3 Pleasant Ave Amendment App & Fast Track

From: John Shields <jshields1@maine.rr.com>
To: "Laurie Leader" <lr@portlandmaine.gov>
Cc: "Bob Gaudreau" <Bob@hardypond.com>
Date: Mon, 23 May 2016 12:31:01 -0400
Subject: 3 Pleasant Ave - Revision No 4

1) BASEMENT PLAN
1/4" = 1'-0"

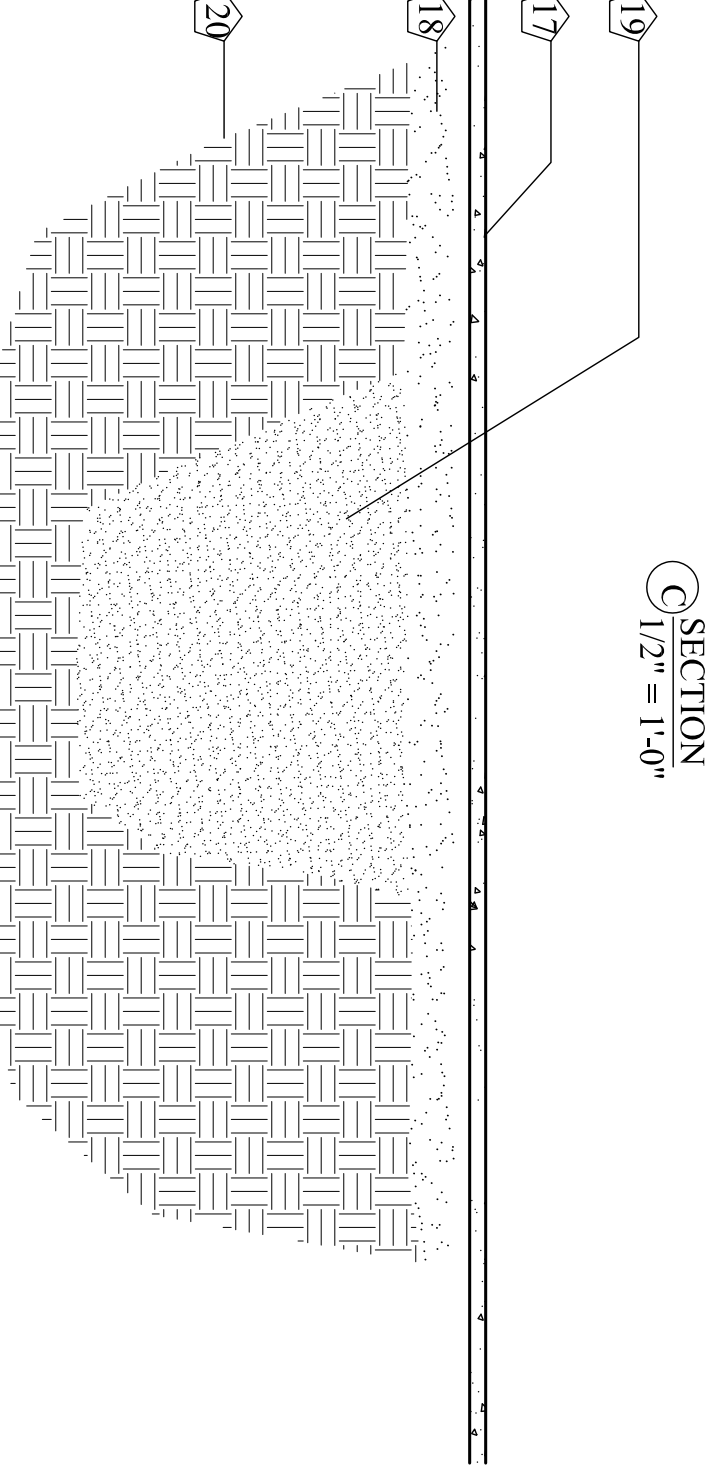
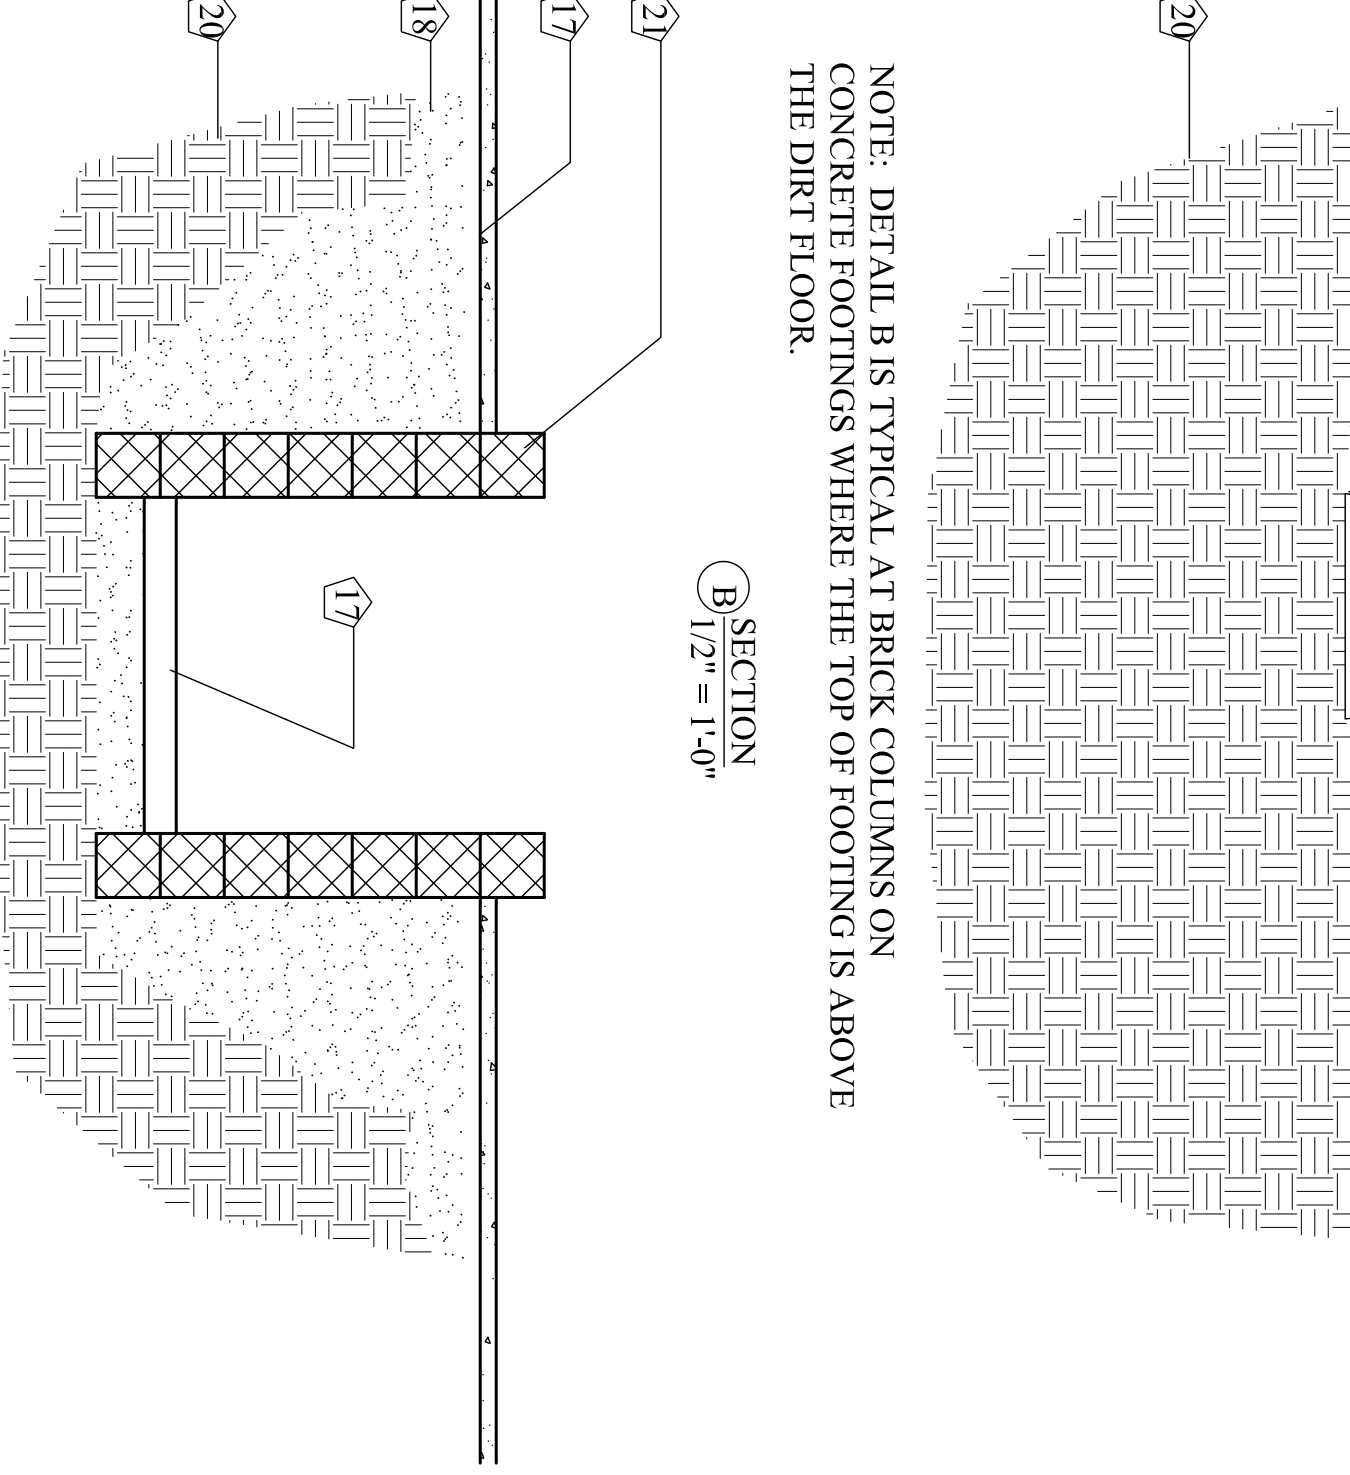
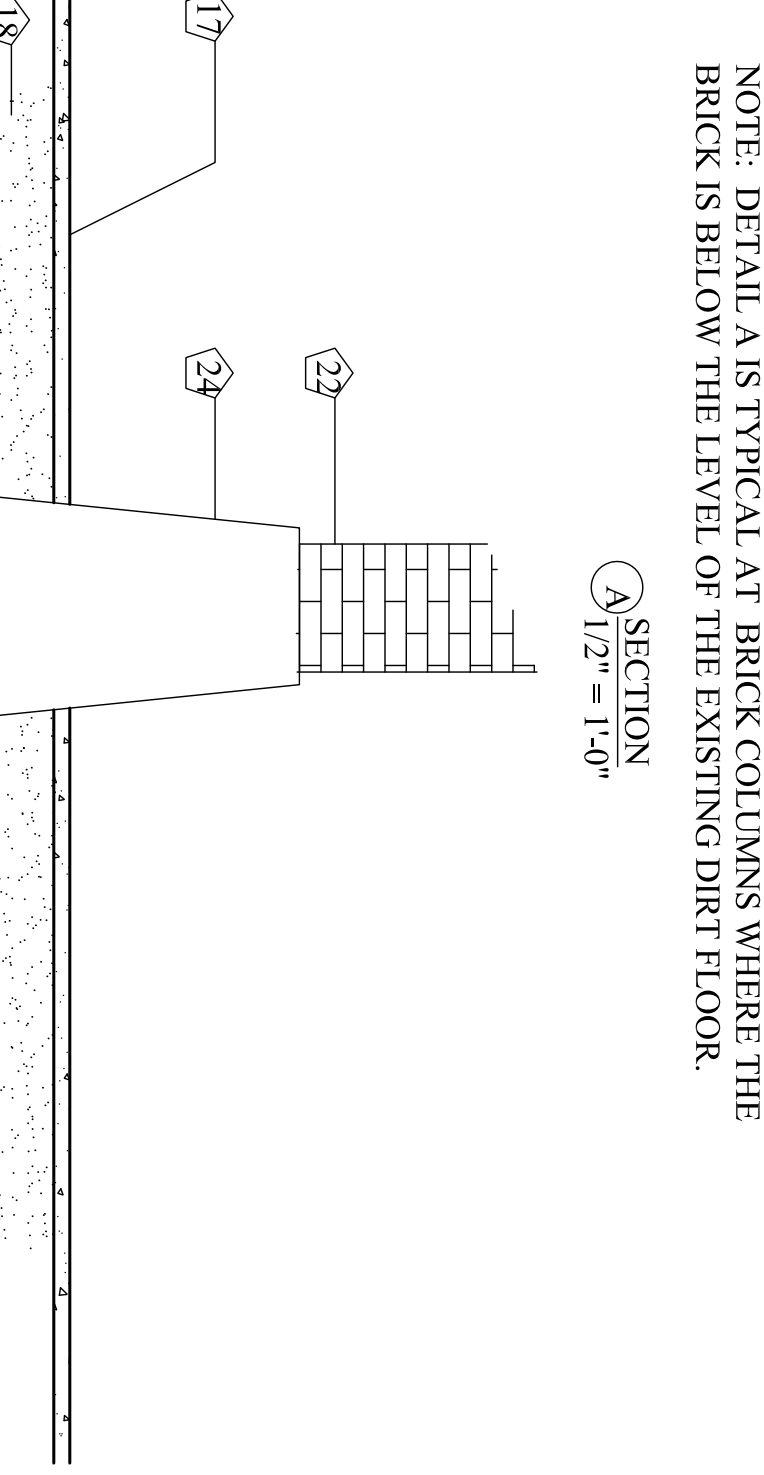
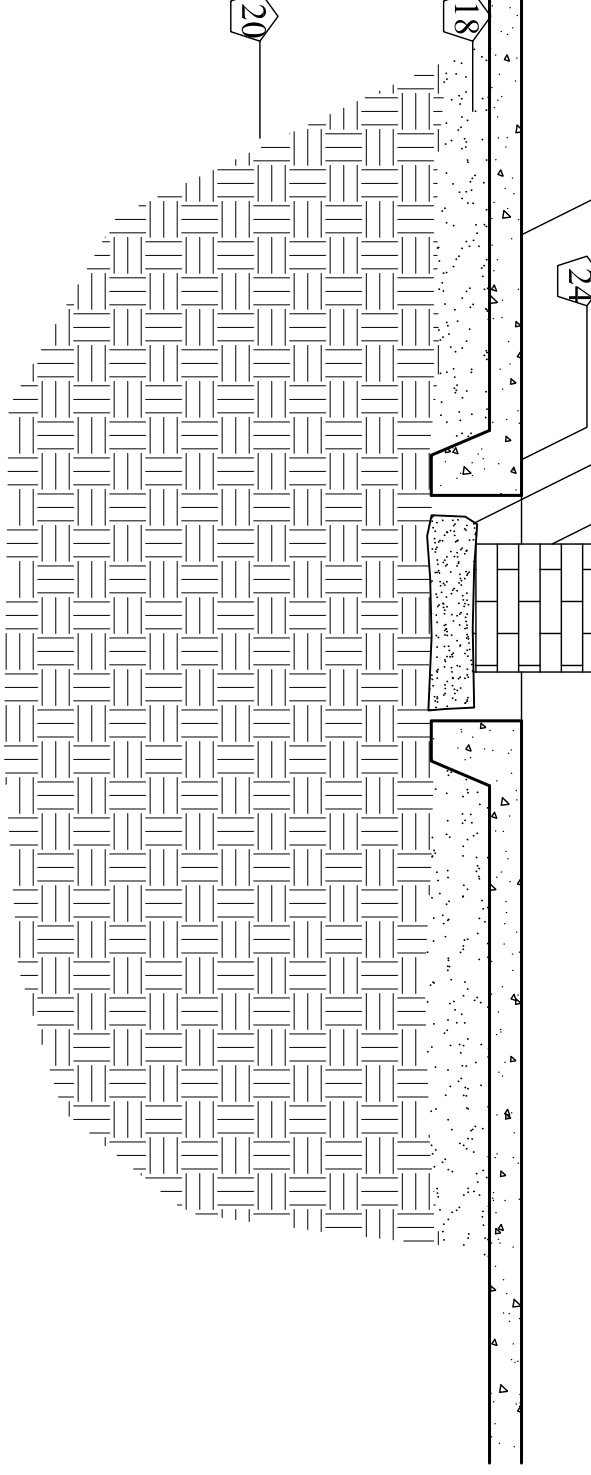
1. Drawing A-2 Basement Plan: Mechanical Room 008 has been moved from Basement 002 to Basement 001.
2. Drawing A-3 First Floor Plan: Numerous closet door changes, interior layouts of Units 106 & 107 changed, Foyer 119 expanded to include postal boxes, Laundry 118 reduced in size.

**SOUTH & EAST  
ELEVATIONS**

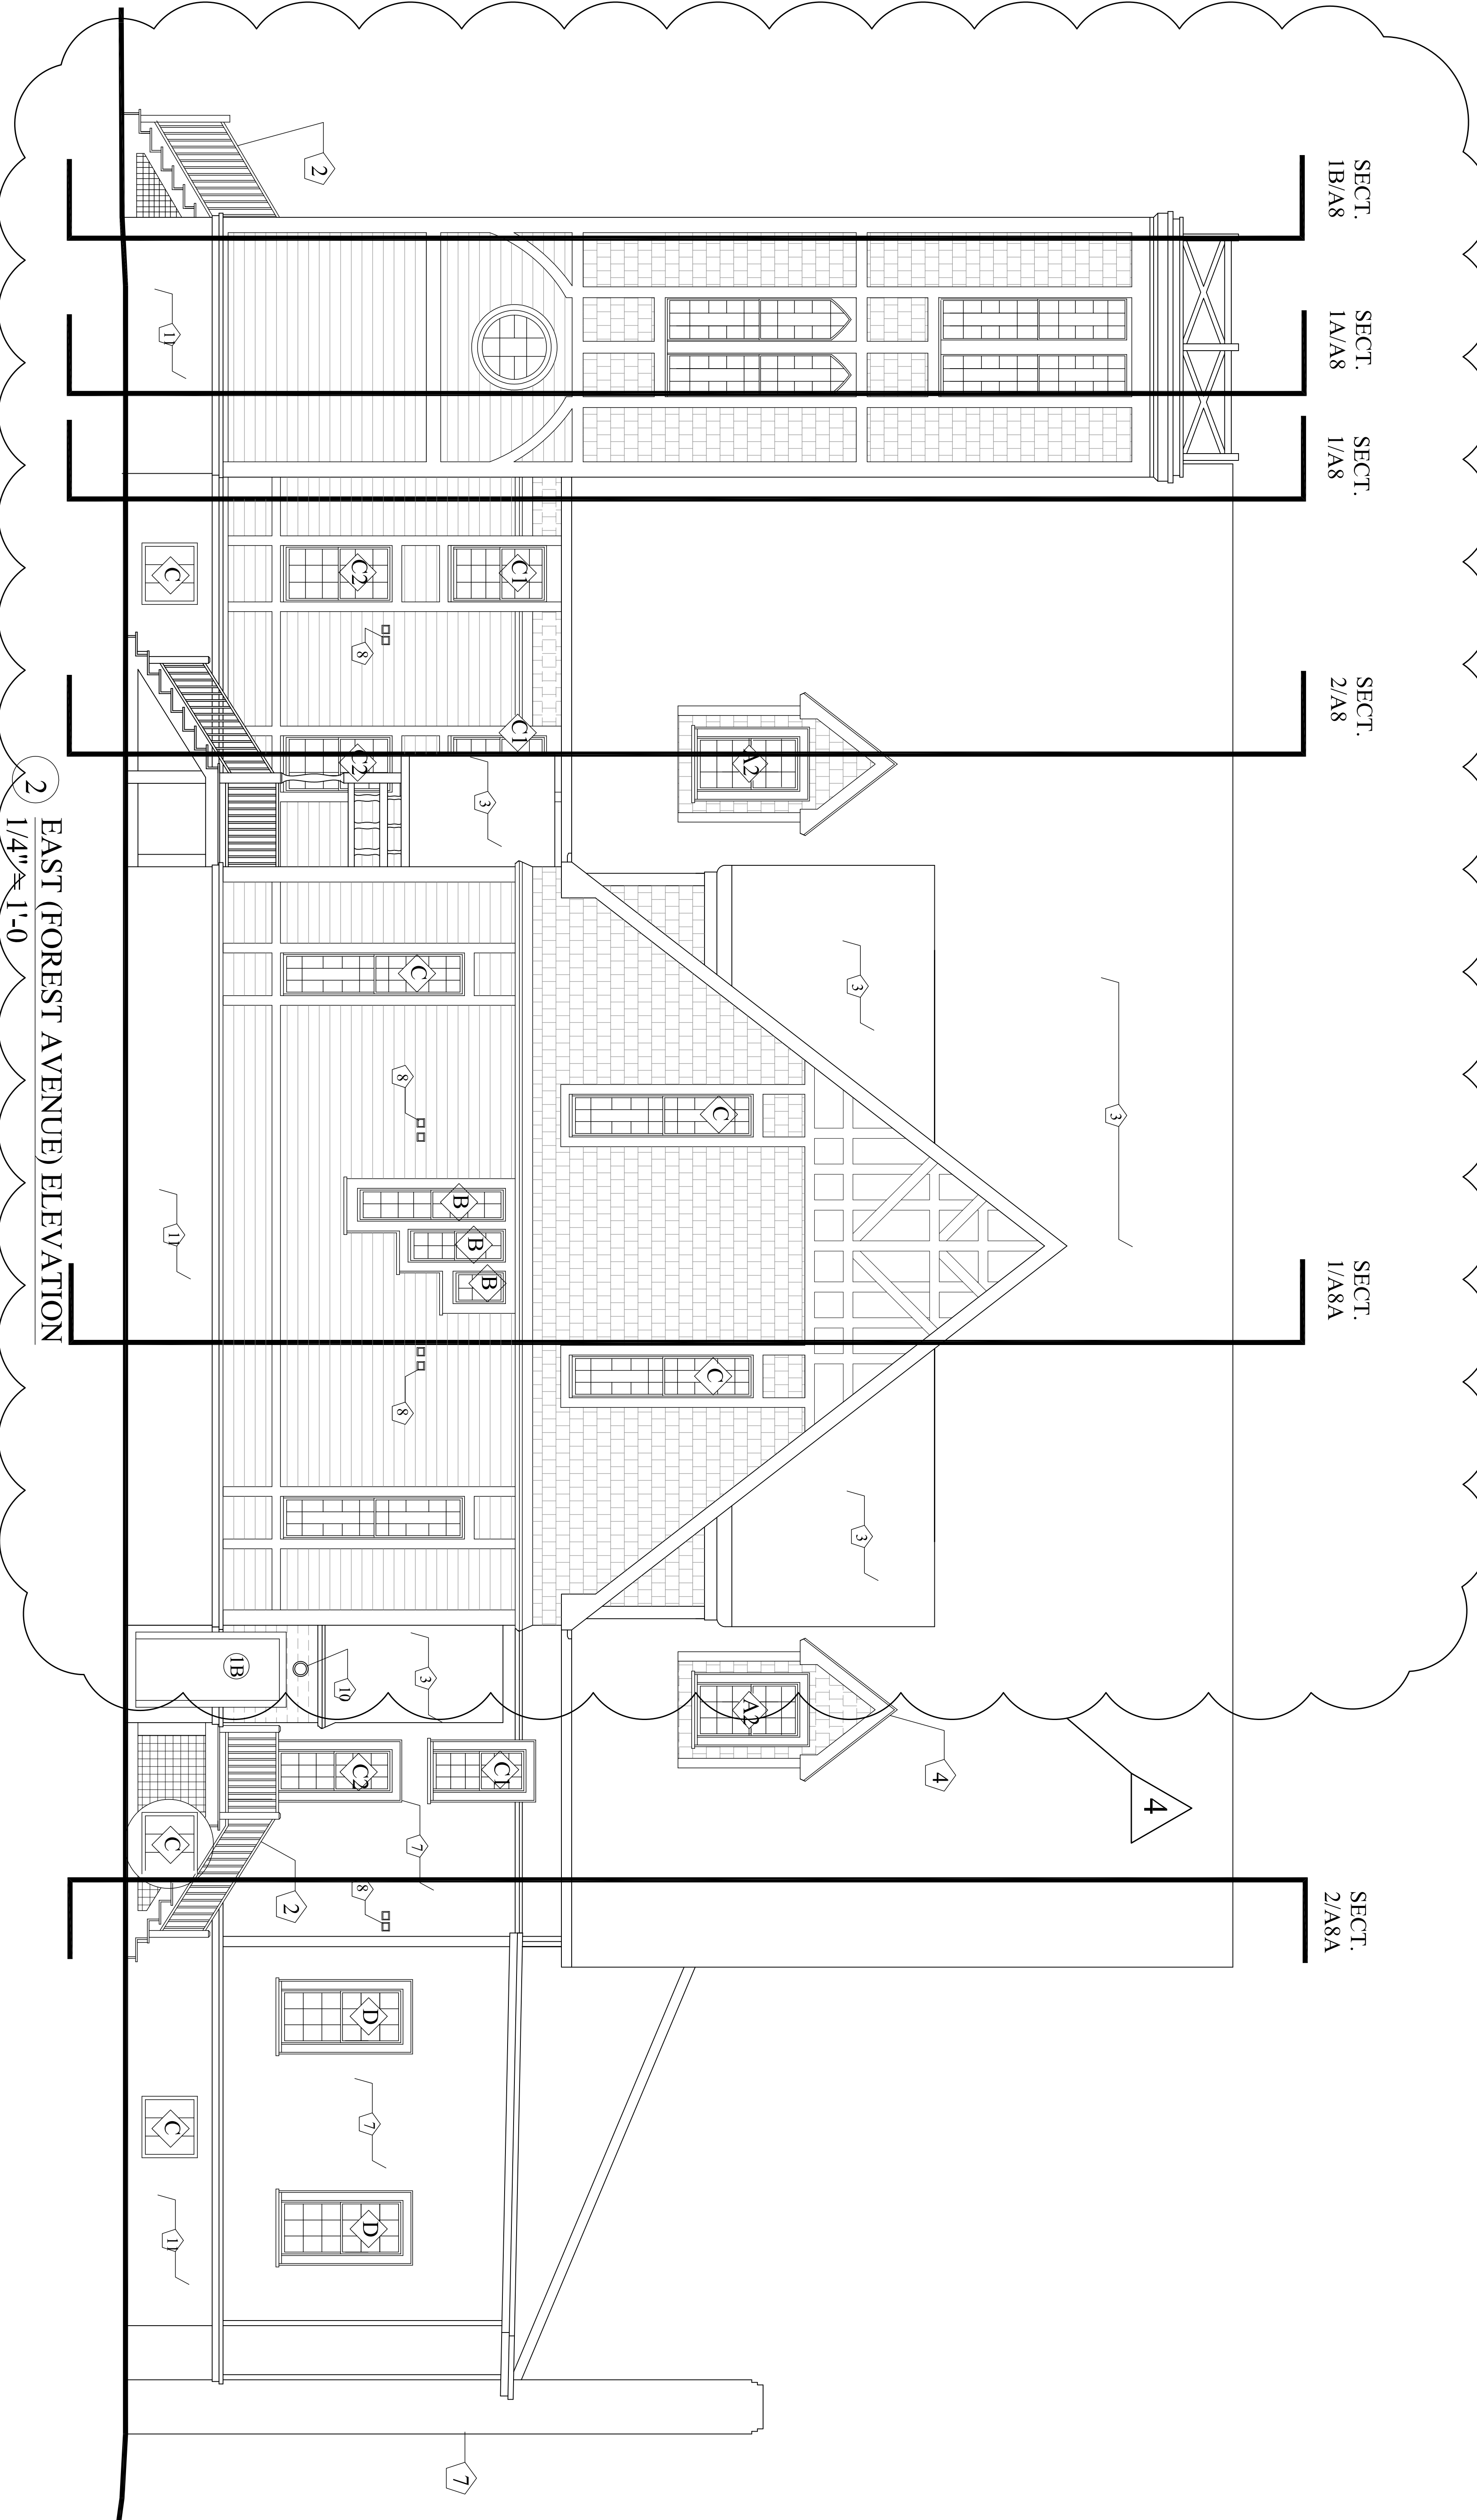
5. Drawing A-6 Exterior Elevations: Elevations changed in some areas to show removal of existing vinyl siding and painting of existing siding.
6. Drawing A-7 Exterior Elevations: Elevations changed in some areas to show removal of existing vinyl siding and painting of existing siding.
